The Secretary
NSW Planning, Industry & Environment

4 March 2021

I refer to the Department's below email of 16 February 2021 regarding the Notice of Exhibition for the Environmental Impact Statement (EIS) for State Significant Development SSD-9794683 for the Oakdale West Estate (OWE) Stage 3 for the construction, fitout and operation of four warehouses with associated office space, car parking, landscaping, services and utilities. Modifications to the approved Concept Plan and Stage 1 DA located at 2-18 Adlington Road, Kemps Creek (Lot 11 DP 1178389) in the City of Penrith LGA. Submissions need to be made to the Department by 17 March 2021.

Lot 2B
Amazon Warehouse Facility
(Currently Under Construction)

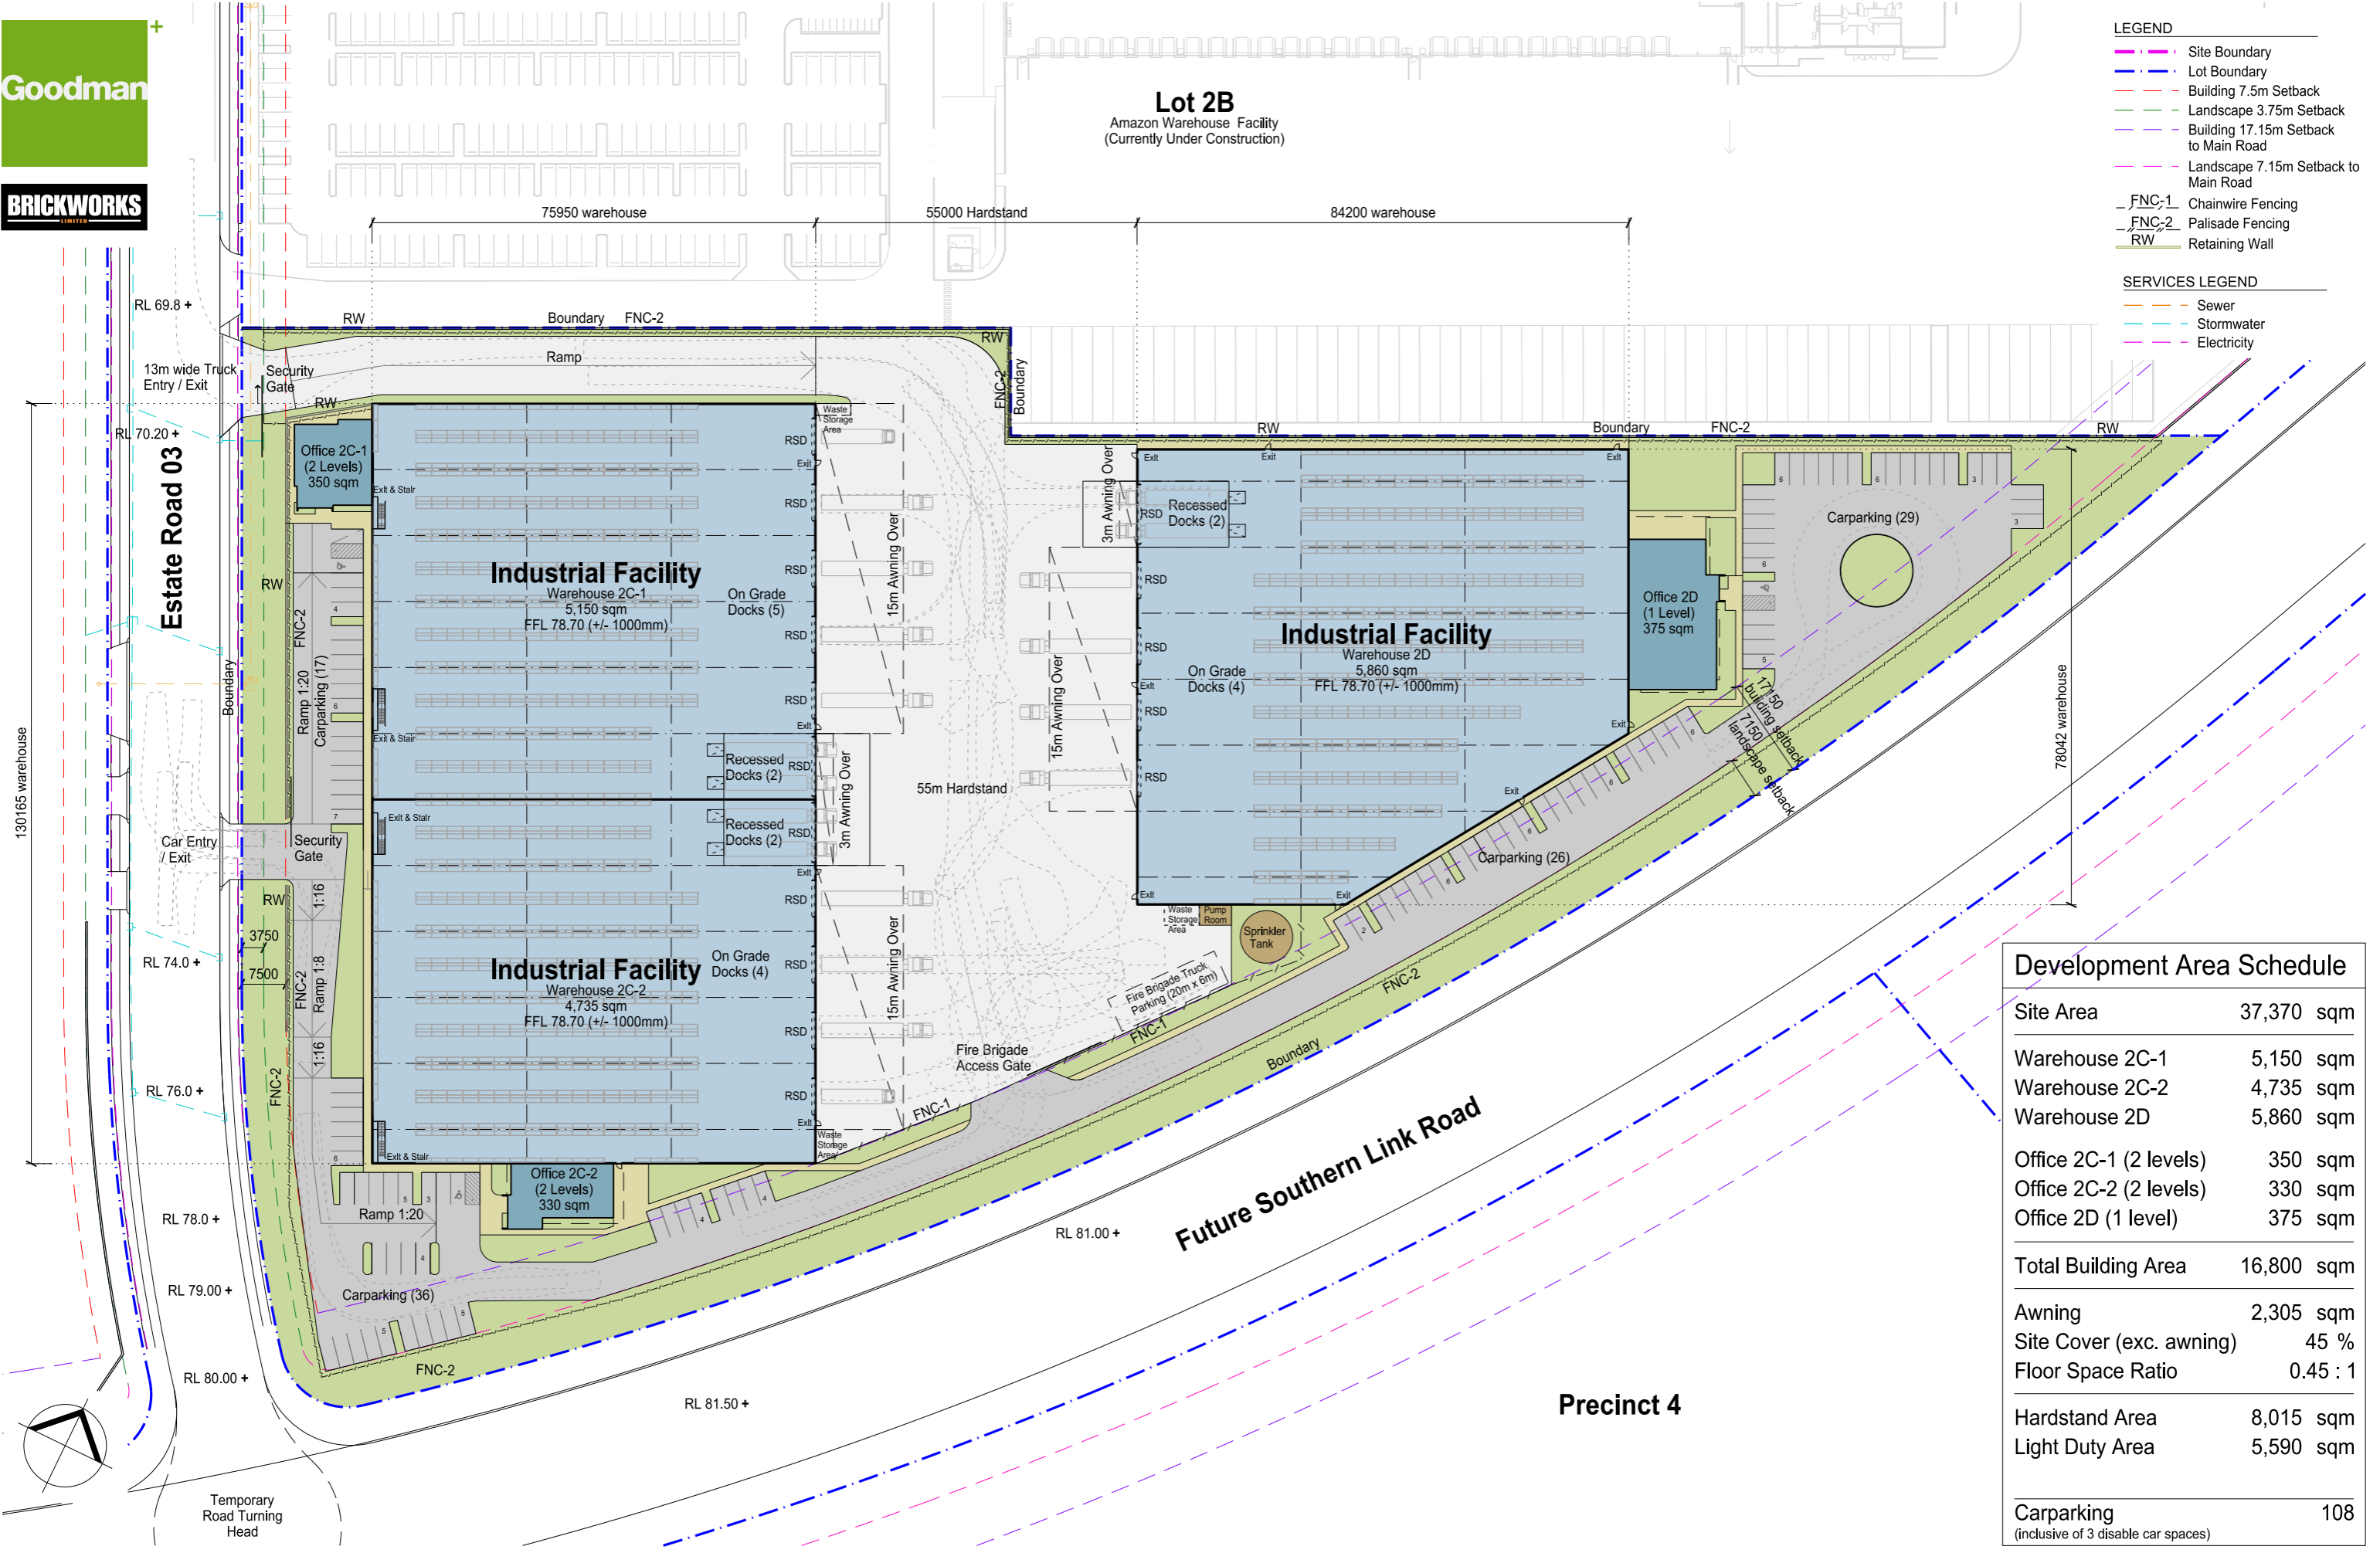
Arrangements have been made via Network Connections Branch for a load application for Site 2C - Warehouse A & Warehouse B as shown in the following Preliminary Site Plan.

The now proposed Industrial Facility as shown in the following extract of Site and Warehouse Plan from Appendix C – Architectural Plan, differs considerably to that proposed in Preliminary Site Plan. Therefore the applicant must contact Endeavour Energy's Network Connections Branch (contact via Head Office enquiries on business days from 9am - 4:30pm on telephone: 133 718 or (02) 9853 6666) to ensure the current load application is consistent with the actual development now proposed.

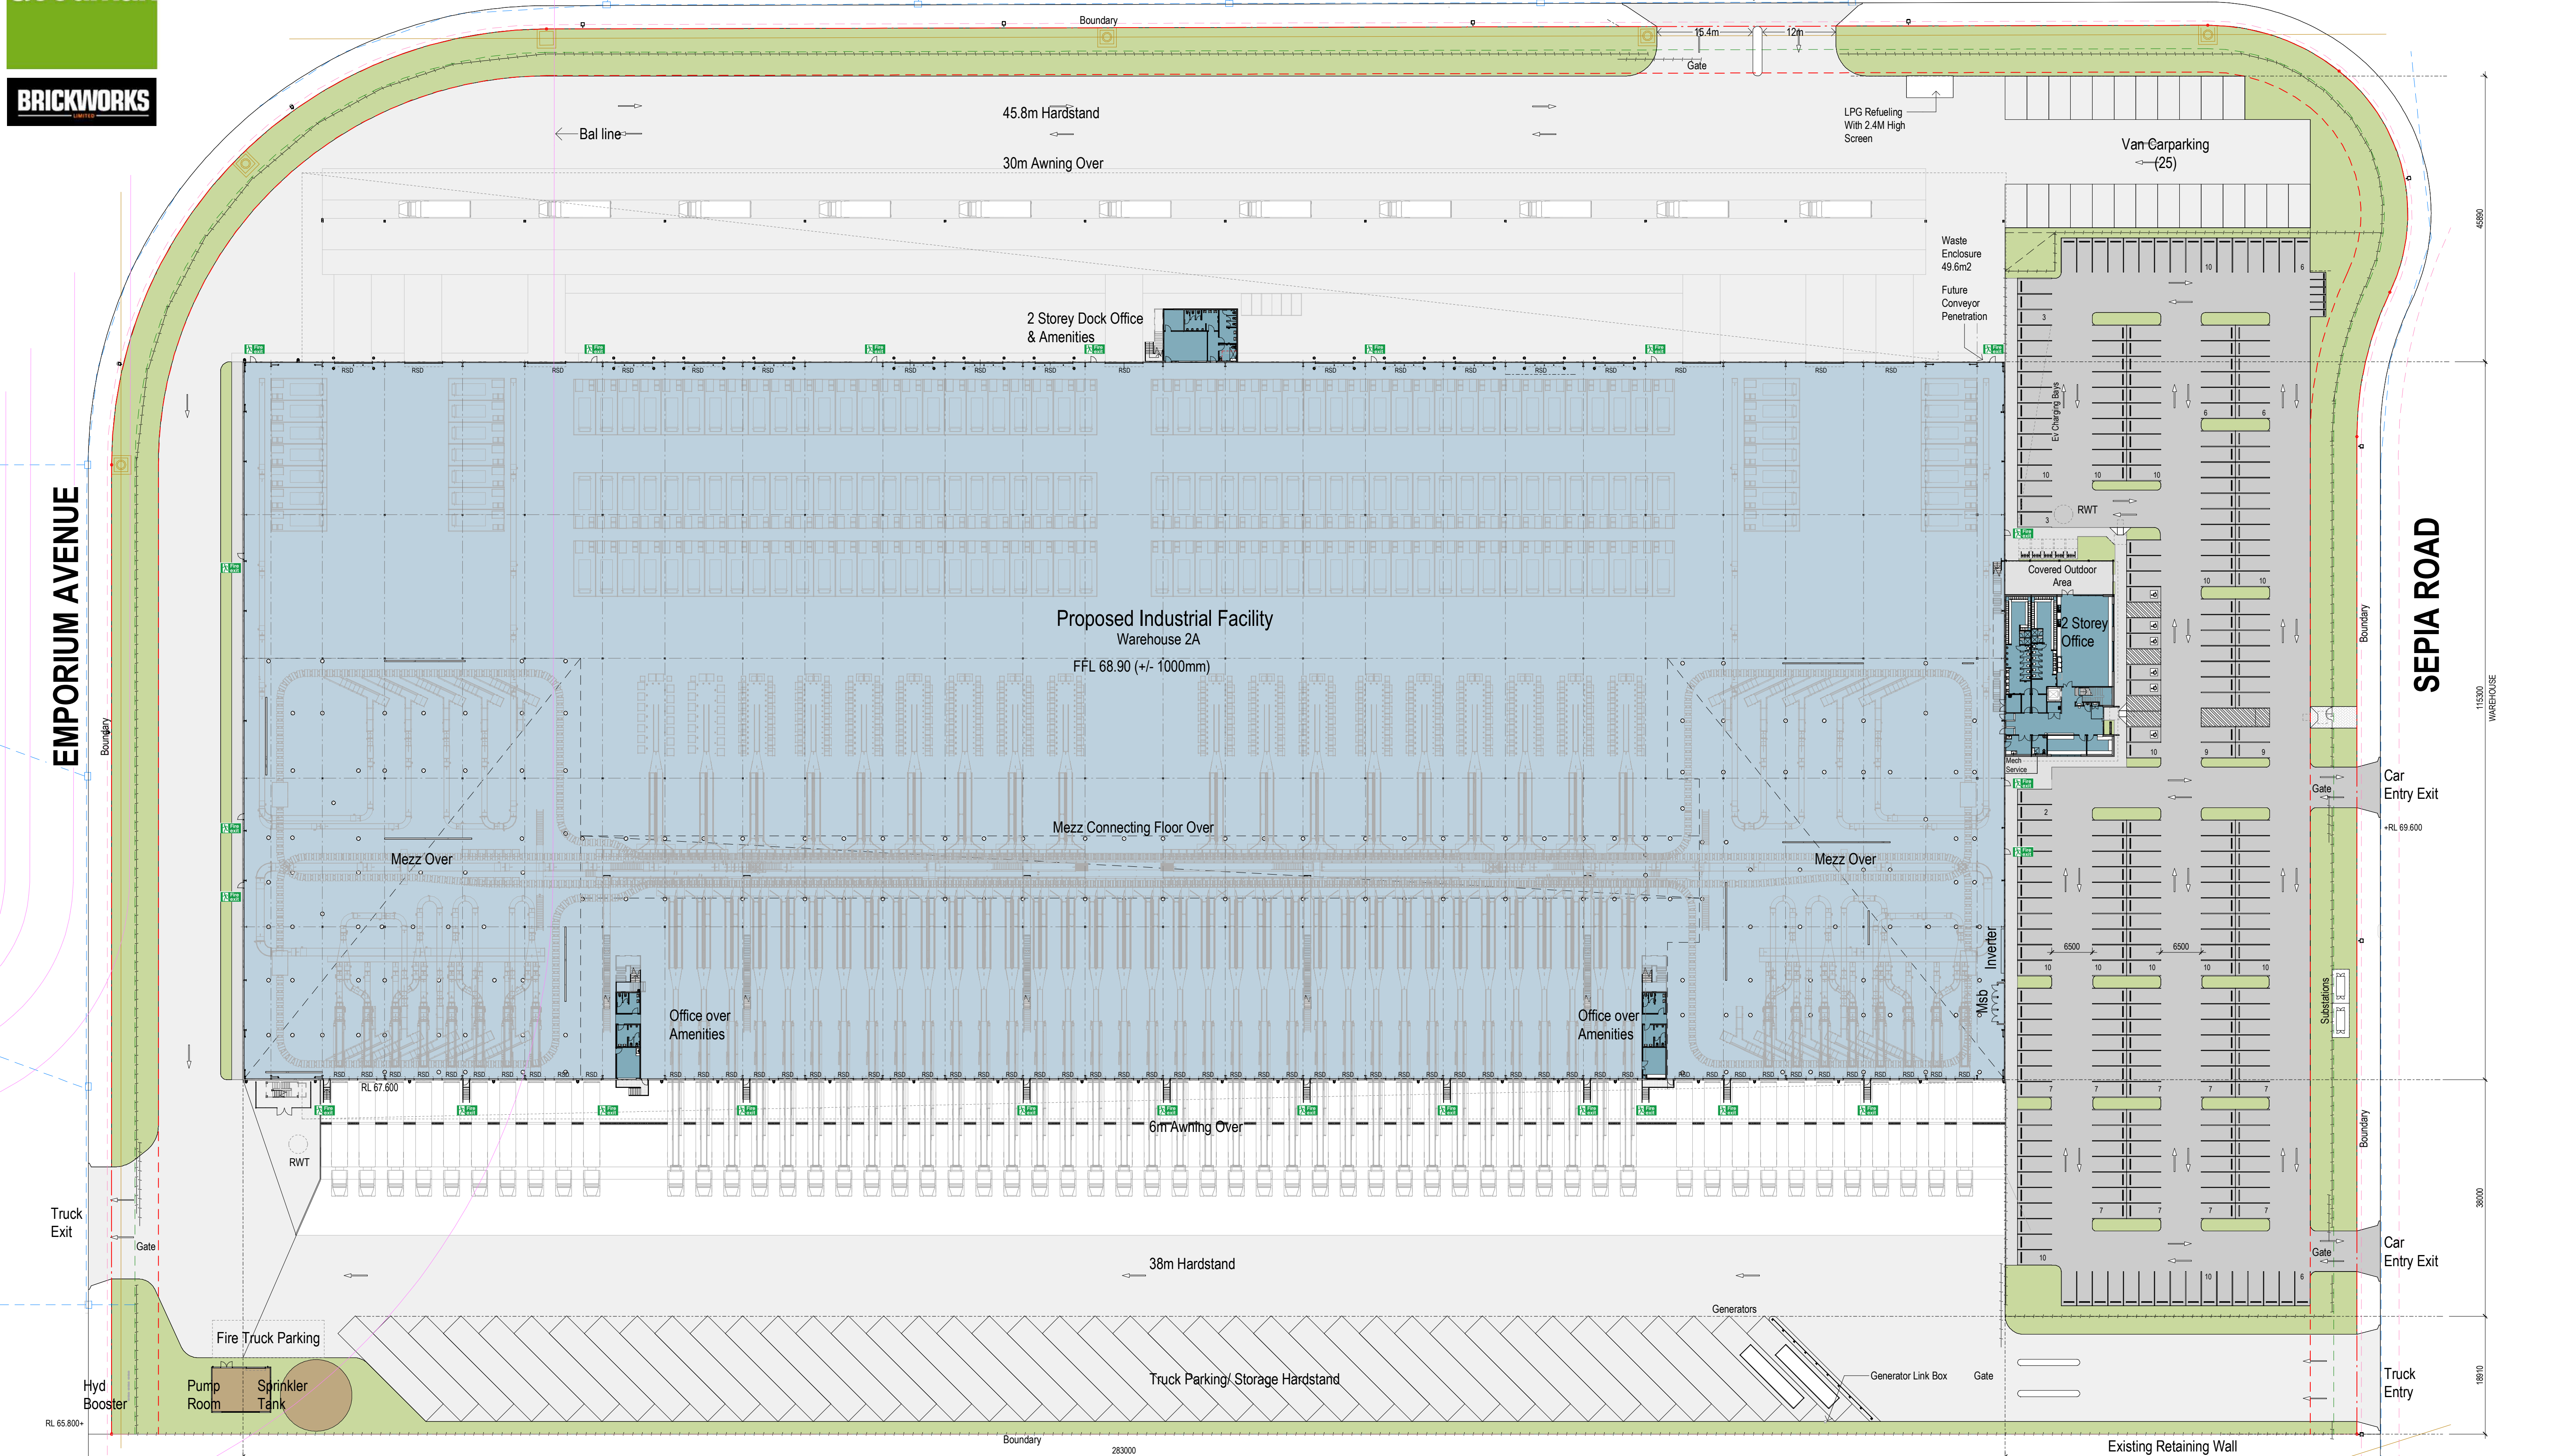
- Architectural Plans. No apparent provision for padmount substations.
- Civil Works Package 1000-Series Infrastructure. No apparent provision for padmount substations.
- Bushfire Hazard Assessment
